Reviewed for Code Compliance
Inspections Division
Approved with Conditions
Date: 03/02/15

Renovations of 11 Idaho Street, Portl

Structural Repairs

2nd Floor plan. existing Dimensions

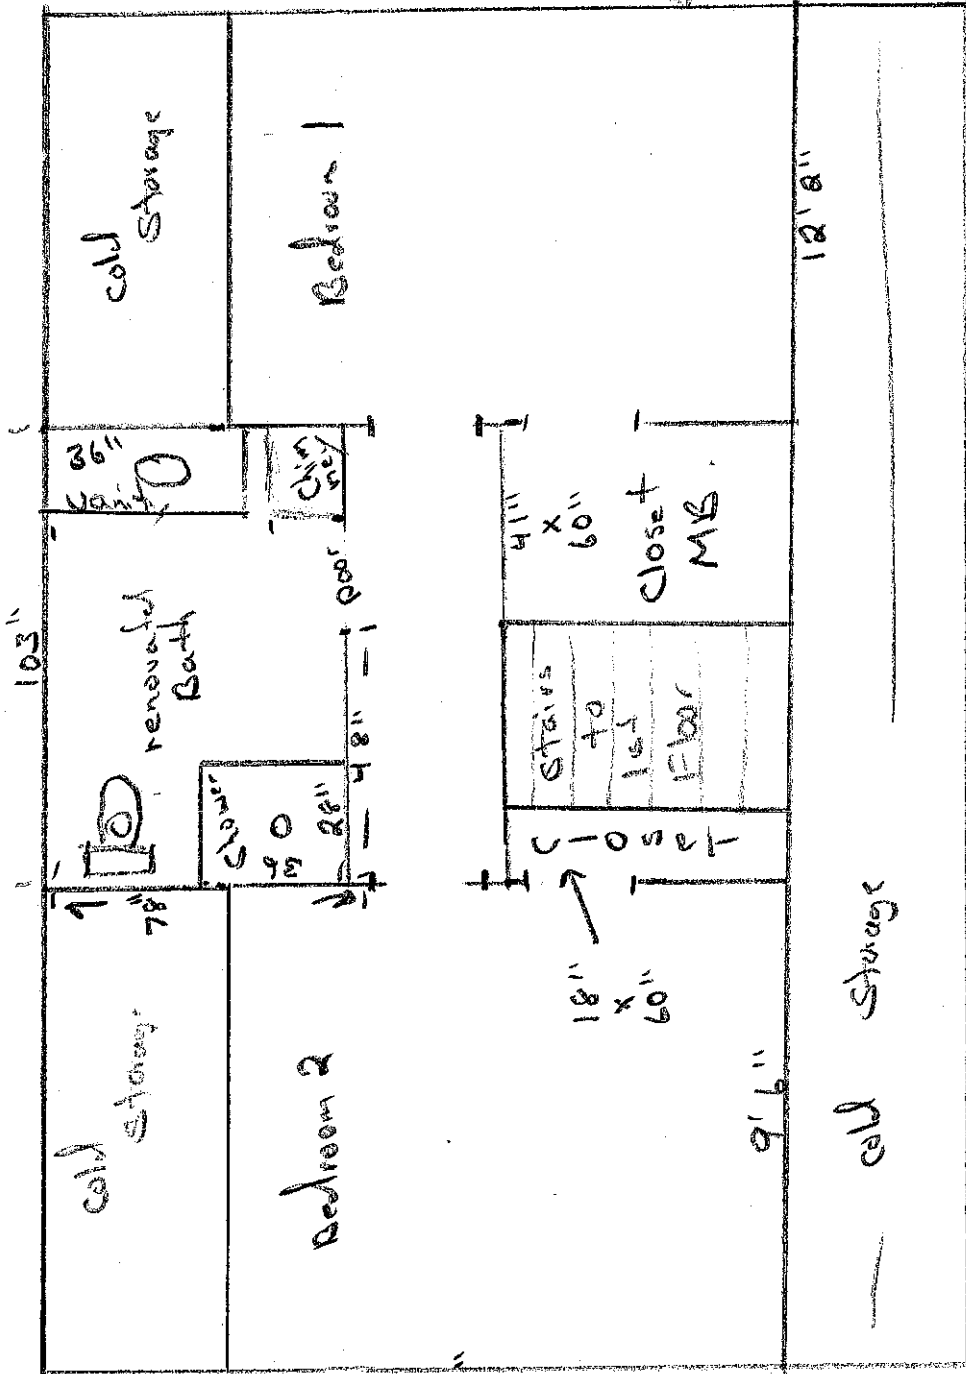
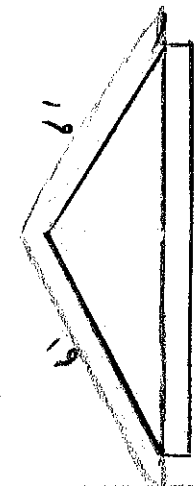
Provide structural support for the main roof rafters being cut for the dome.

Dormer plan

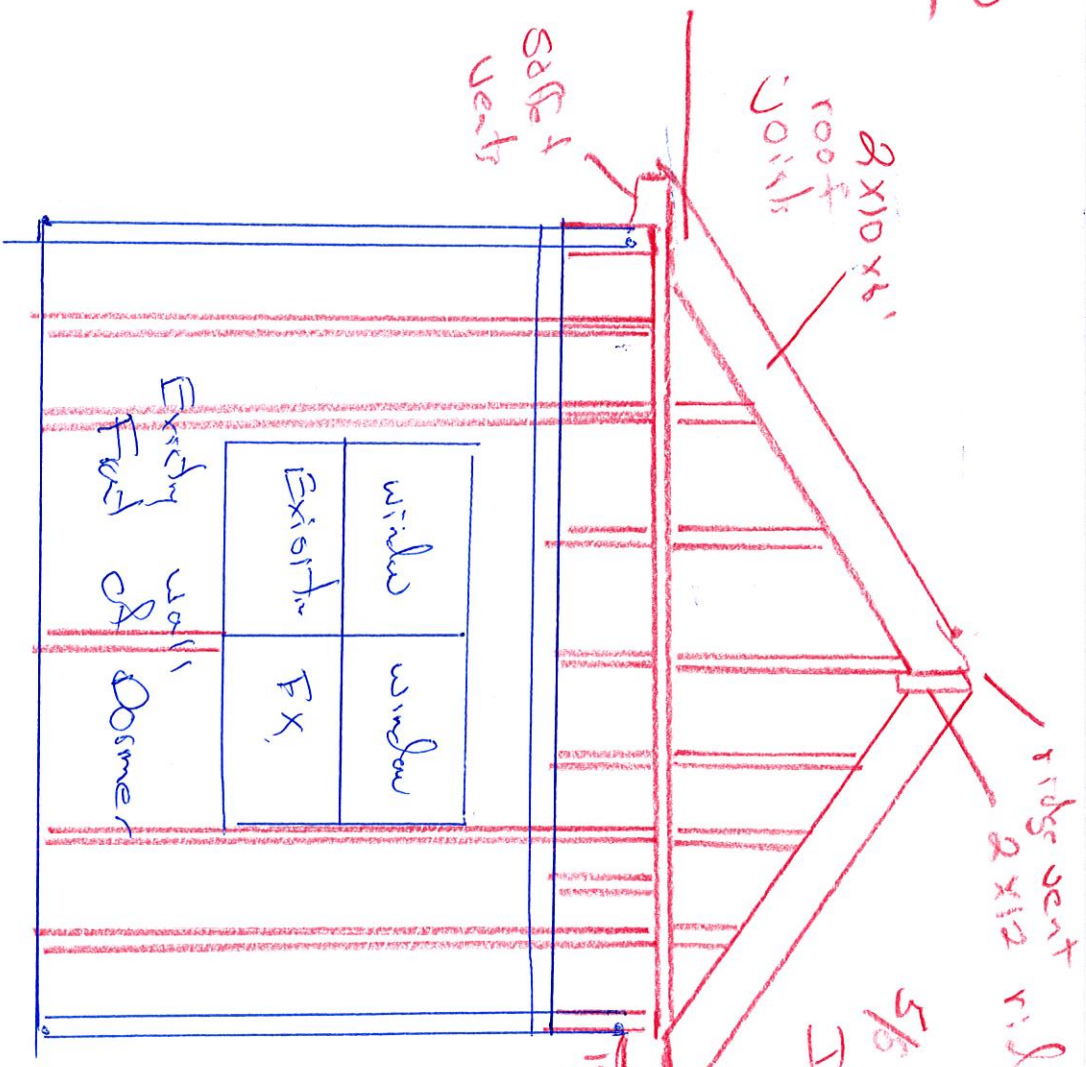
Provide details for the structural support of the main roof rafters that are being cut for this dormer.
